# KIRKLEES METROPOLITAN COUNCIL INVESTMENT & REGENERATION SERVICE

### DELEGATED DECISION TO DETERMINE PLANNING APPLICATIONS

| Reference No:         | <b>2024/62/90732/W</b>                                                        |
| Description:          | Erection of single storey rear extension and loft conversion with rear dormer |

Plans & Elevations - As Proposed

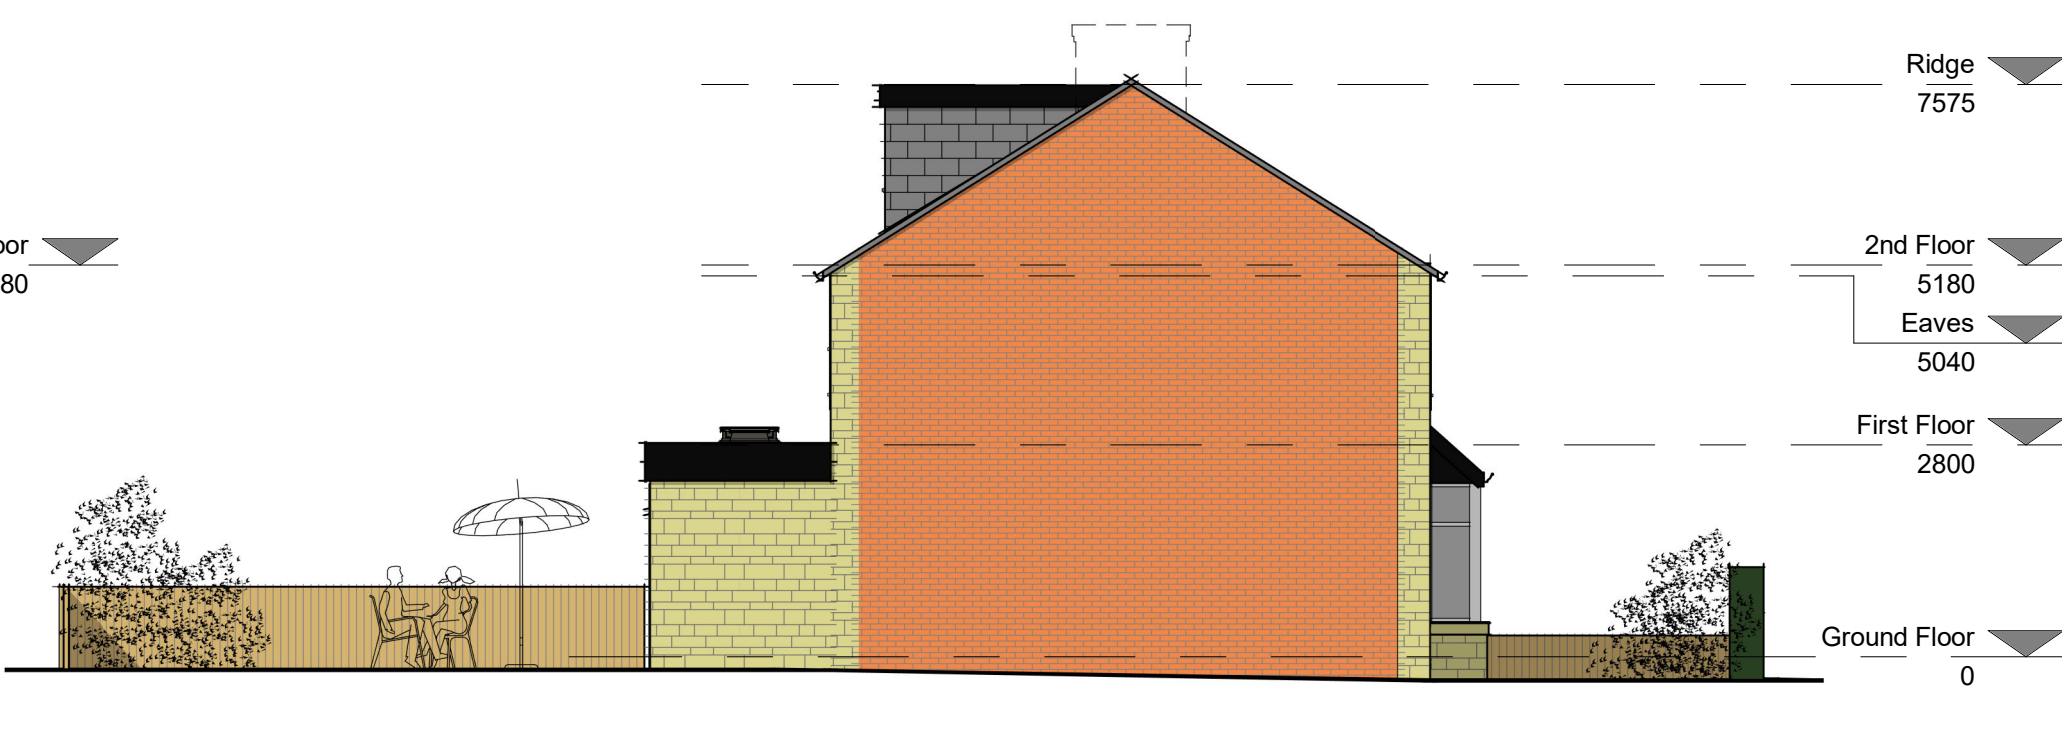
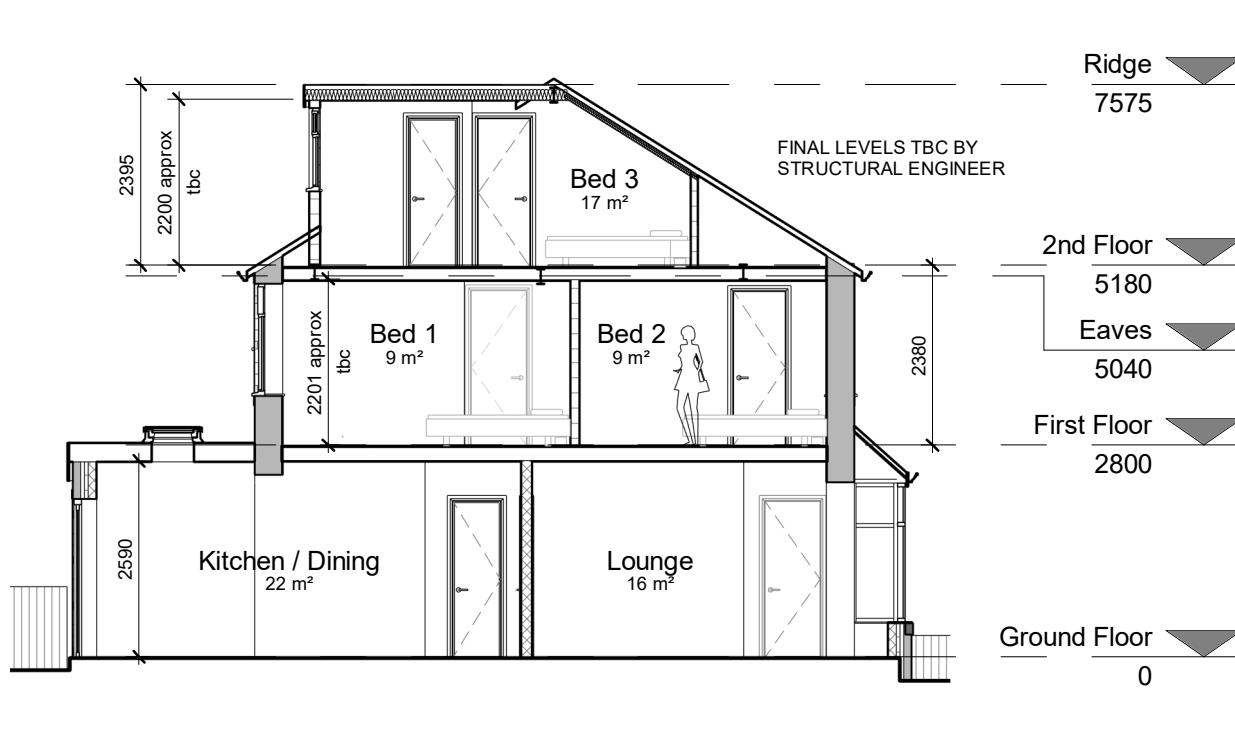
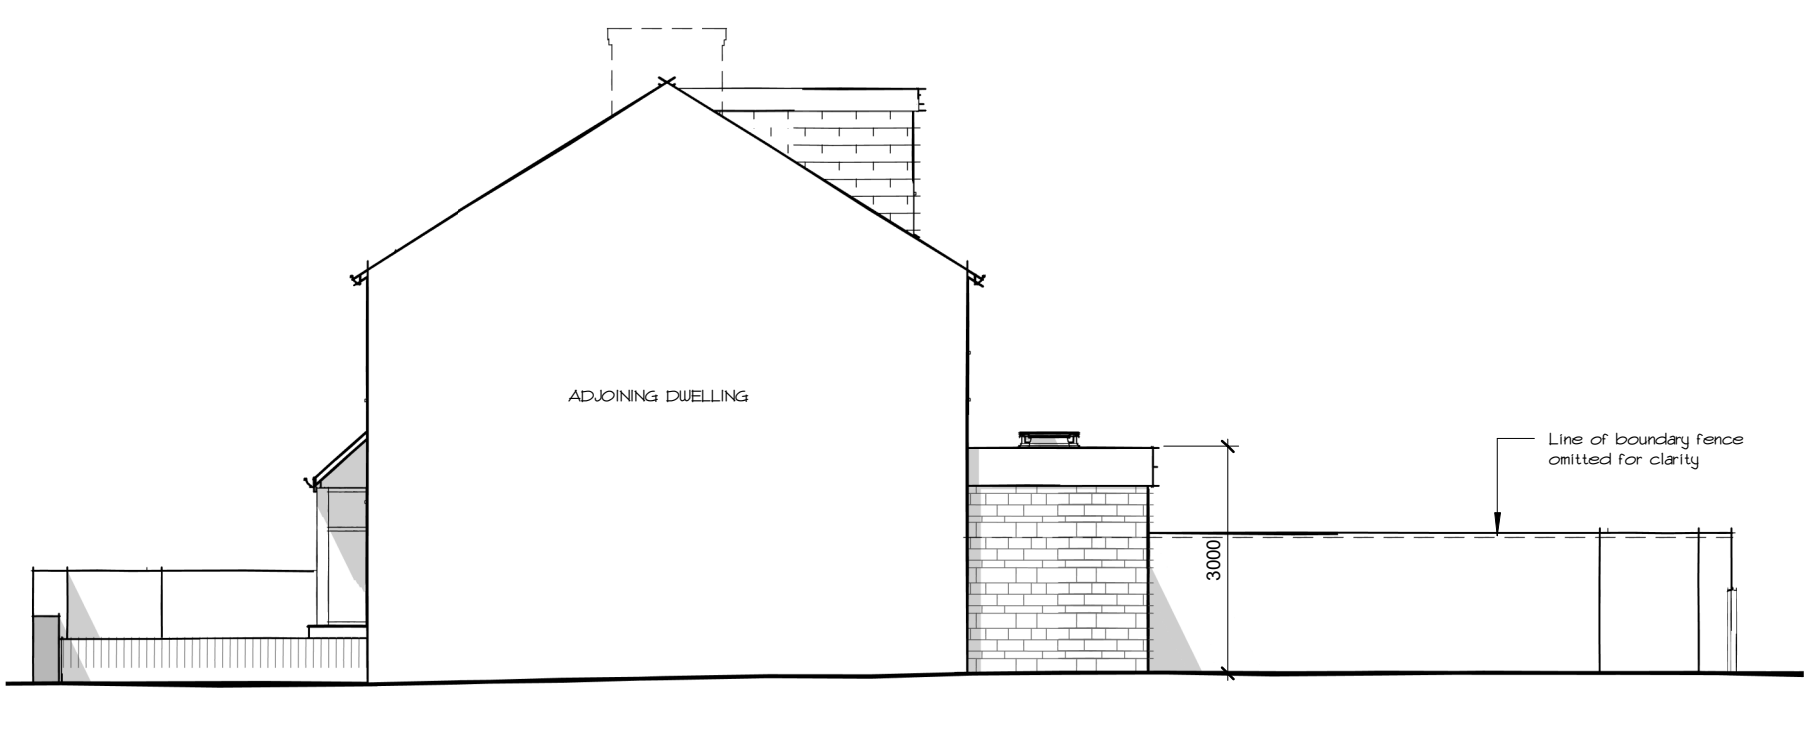
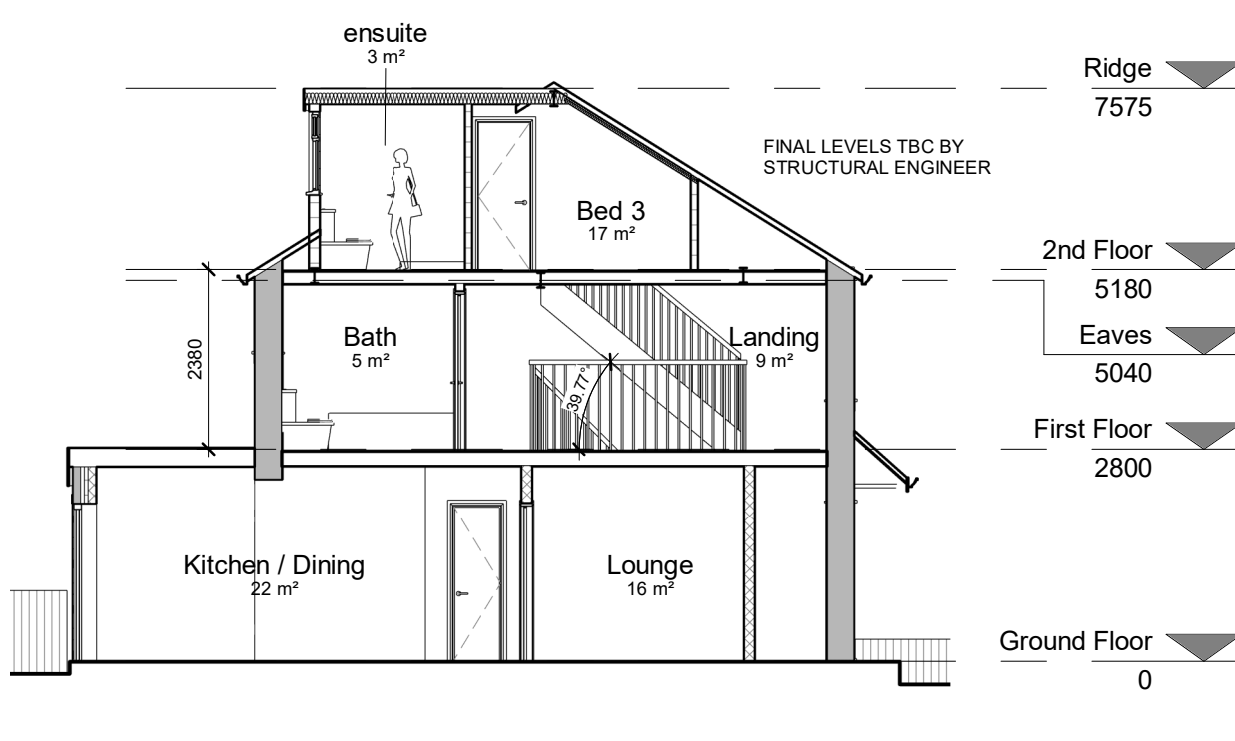
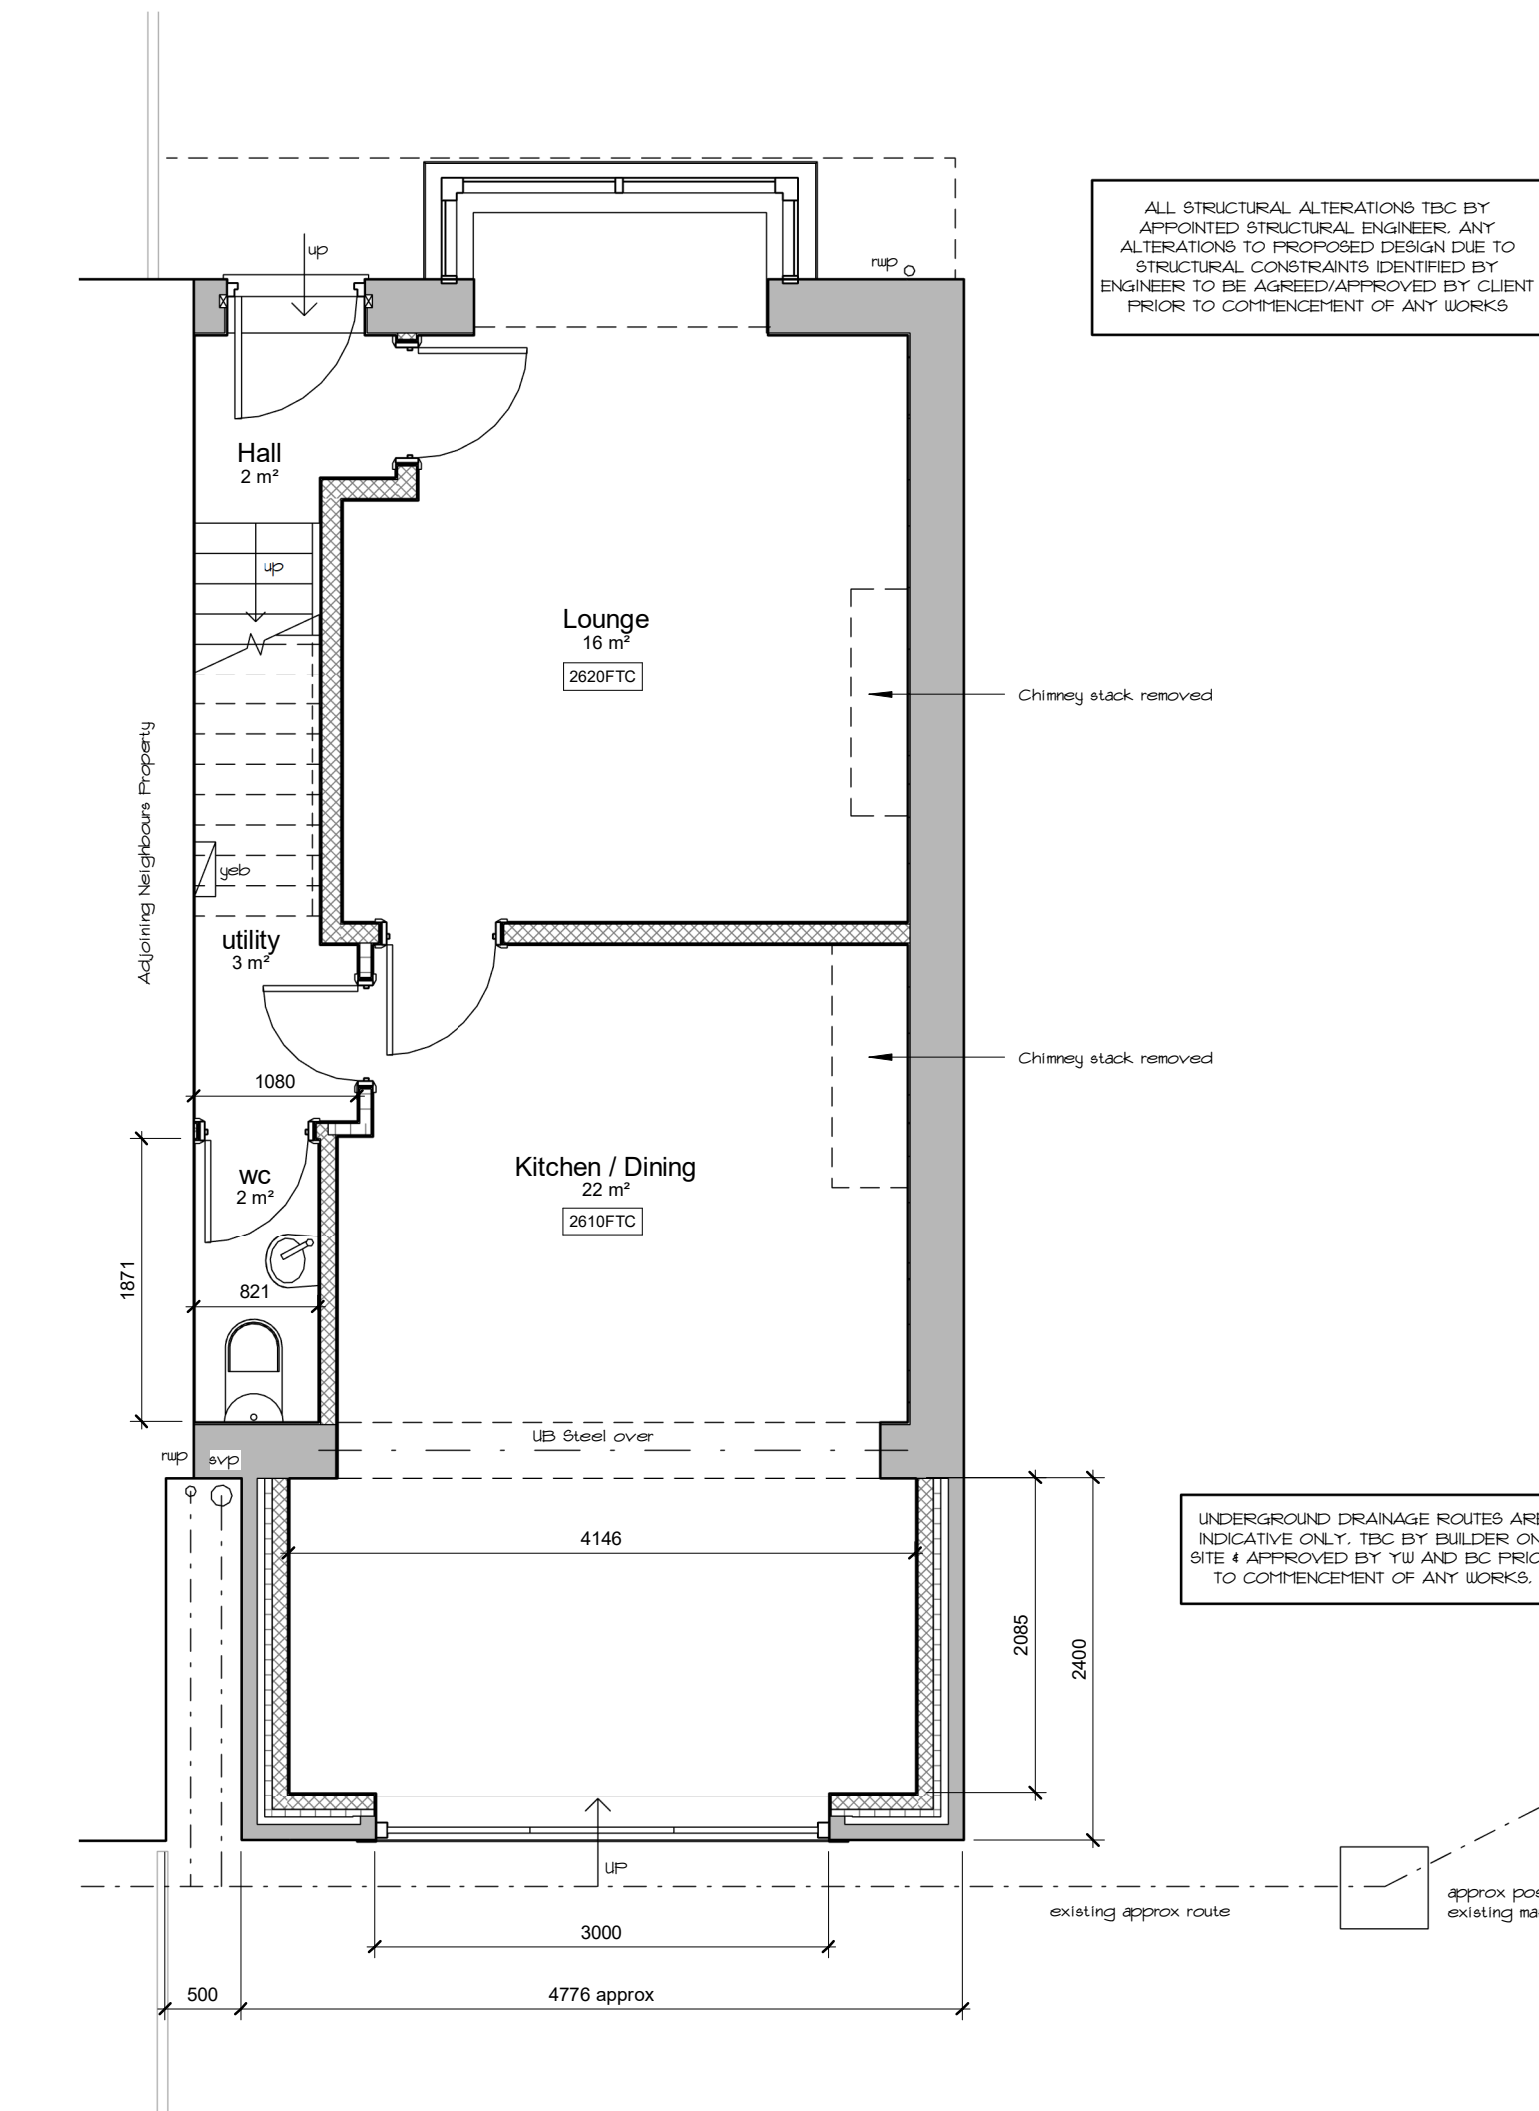
- ~2.4 metre projection
- ~4.7 metre width
- ~2.5 metre eave height
- ~3 metre total height

- ~5 metre width
- ~2 metre height
- ~3.2 metre front projection

The chimney stack would be removed as part of the works.

| retain a gap of at least 1 metre from a property boundary, such as a wall, fence or hedge                                                               | The extension would be constructed along north-west facing boundary. | The rear extension at the application property would lie flush with the rear outrigger of adjoined neighbour, No 68. Although against SPD guidelines, there would be no visual benefit of setting the extension off the boundary by 1 metre and is acceptable in this case. |

| not dominate the roof or project above the ridge of the house                                            | The dormer would not project above the ridge of the house. It takes up most of the roof, but no more than the pd fallback |  |

The extension would not project beyond the existing ground floor outrigger of this dwelling, therefore the extension would not be detrimental with regard to overshadowing/overbearing. The dormer would overlook the rear garden of this property and would not present any greater impact to privacy than that already exists.
